Application for a Non-Material Amendment Following a Grant of Planning Permission

1. Confirmation that an existing window will not be bricked up (in family bathroom)
2. change of plan for space above garage- we no longer wish to include an en-suite bathroom here

0616-10-23-Proposed First Floor Plan
0616-15-Proposed Elevations
0616-16-sectional Details

Drawing Title
PROPOSED ELEVATIONS

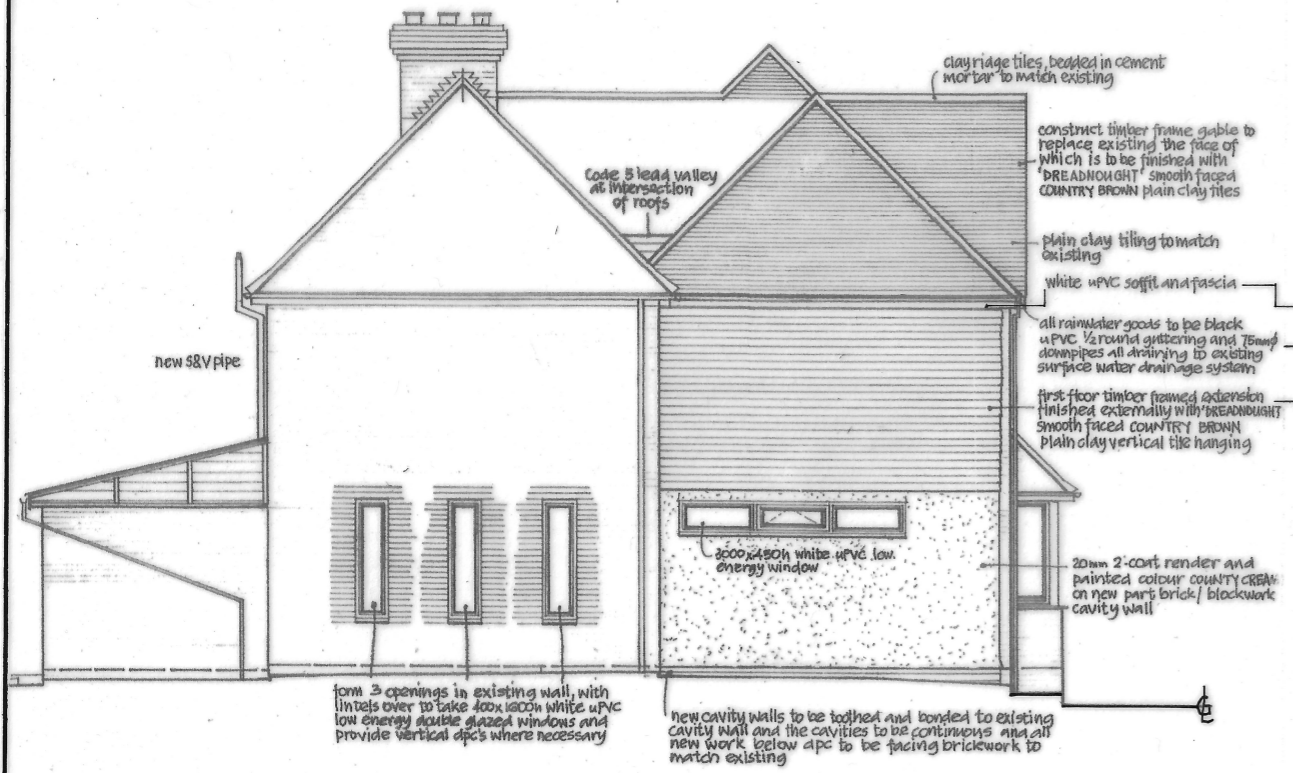
1. confirming that an existing window will not now be filled in- it will remain
2. The original plan showed that the new room above the garage would be split into a bedroom and an en-suite bathroom. This will be changed so that it will only be a bathroom.

1. in relation to the existing window- a change of mind
2. in relation to the en-suite- budget constraints.

Edits are shown in red
